DECISION DELEGATED TO HEAD OF PLANNING

Application No: H20-0060-24 **Applicant:** Scenic Homes
Proposal: Details of verification report (Condition 6 of H20-0296-23)
Location: Land Adj. Havencombe Chapelgate Sutton St James
Terminal Date: 19th March 2024

Enc. 'Sketch of Capping Placement Steps' (Drawing E22108/L05)  
SHDC Comments (07/02/24)

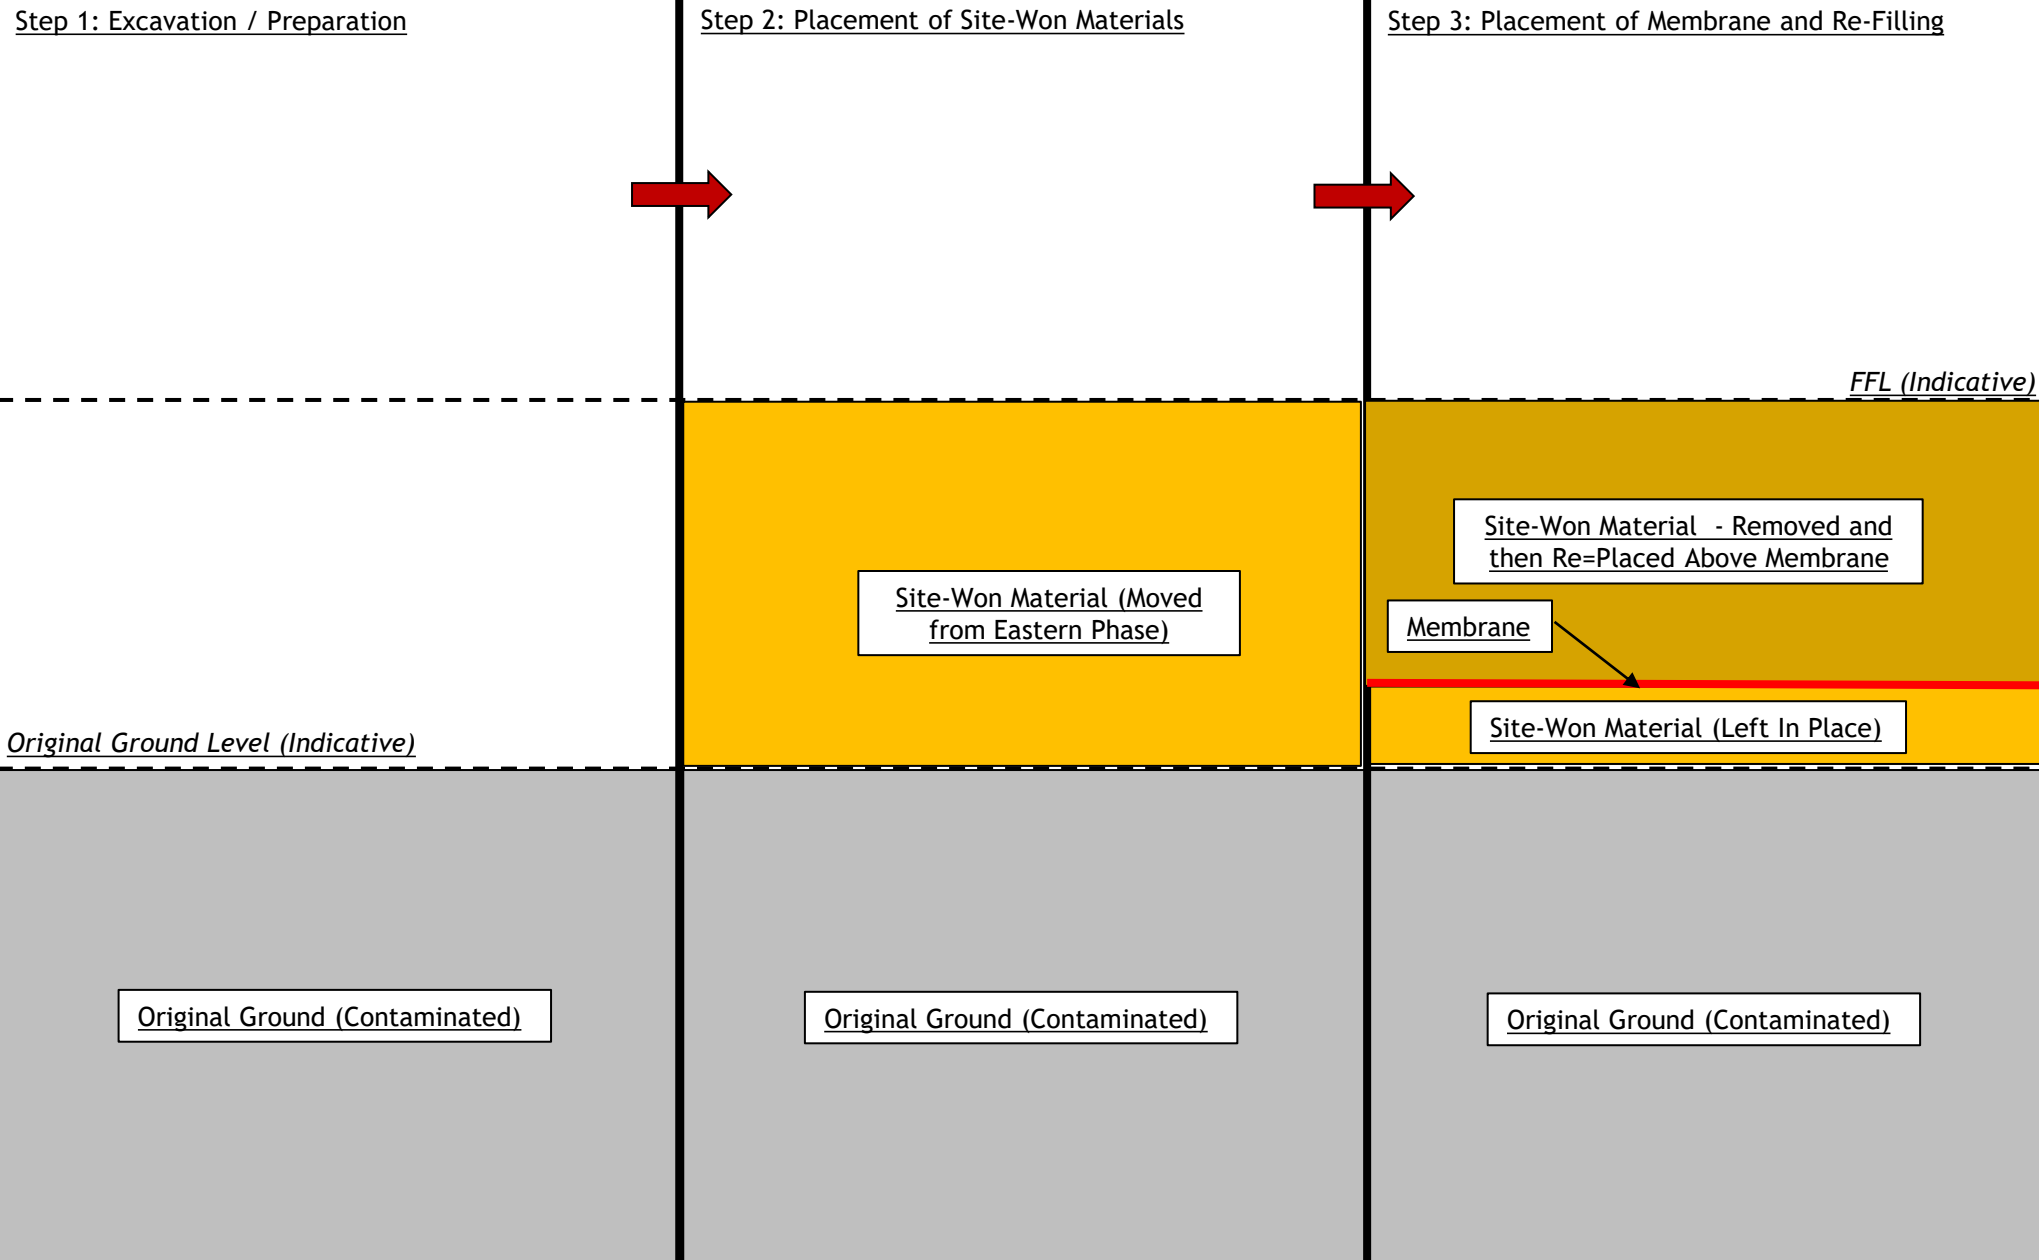
Subsoil material from the paddock site was stored on the piggery site without any physical barrier, despite previous assurances it was being stored on hardstanding. Whilst I appreciate the applicant and consultants' honesty and transparency here, the sketch they have supplied which shows there was a sacrificial layer left behind does not include any scale or annotations to suggest how much of a sacrificial layer was left. Nor does it state who supervised the assessment of where the bottom of the stockpile was, or where the material was then moved to.

In terms of the reuse of material from the paddock site, the sketch showing a sacrificial layer does not include a scale or annotations to suggest how much of a sacrificial layer was left, or who supervised the assessment of where the bottom of the stockpile was, or where the material was then moved to.
